16028 - Rock Island Trail

EL PASO COUNTY GRADING AND EROSION CONTROL PLAN CHECKLIST

EPC Project Number: CDR193

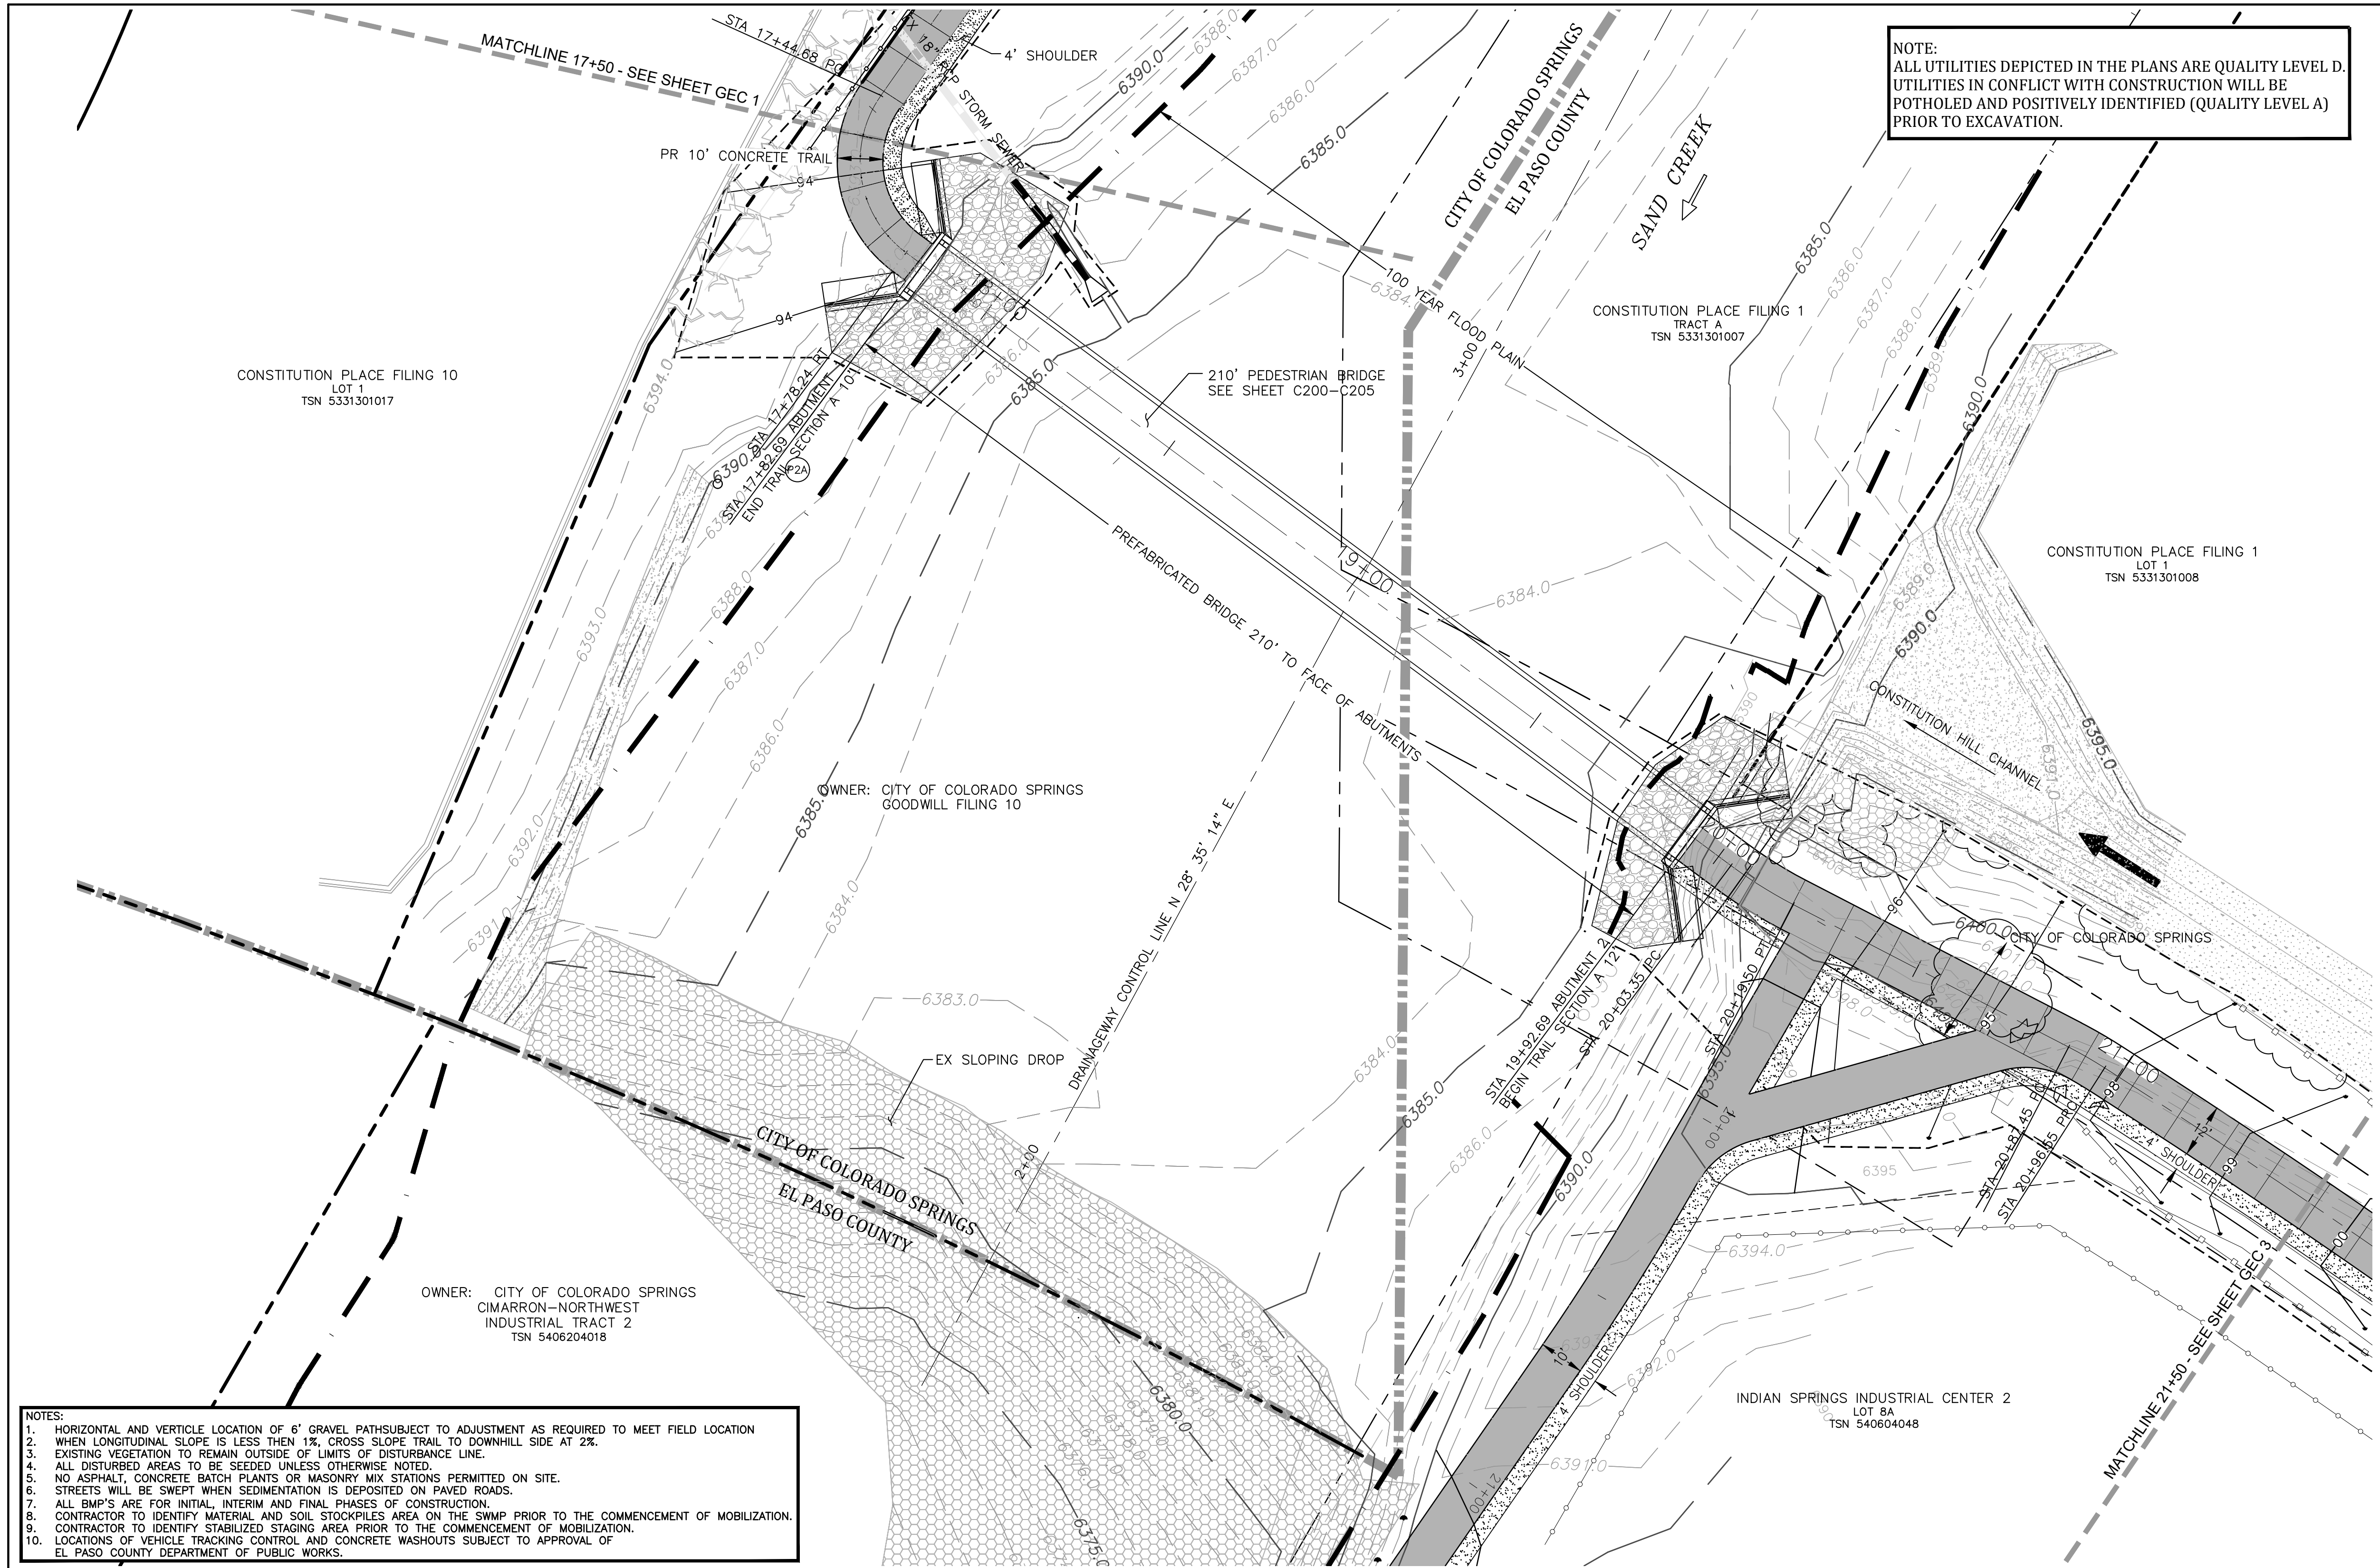
v	All proposed temporary construction control measures, structural and non-structural. Temporary construction control measures shall be identified by phase of implementation to include "initial," "interim," and "final" or shown on separate phased maps identifying each phase		N
w	Vehicle tracking provided at all construction entrances/exits. Construction fencing, barricades, and/or signage provided at access points not to be used for construction		Y
x	Temporary sediment ponds provided for disturbed drainage areas greater than 1 acre		N/A
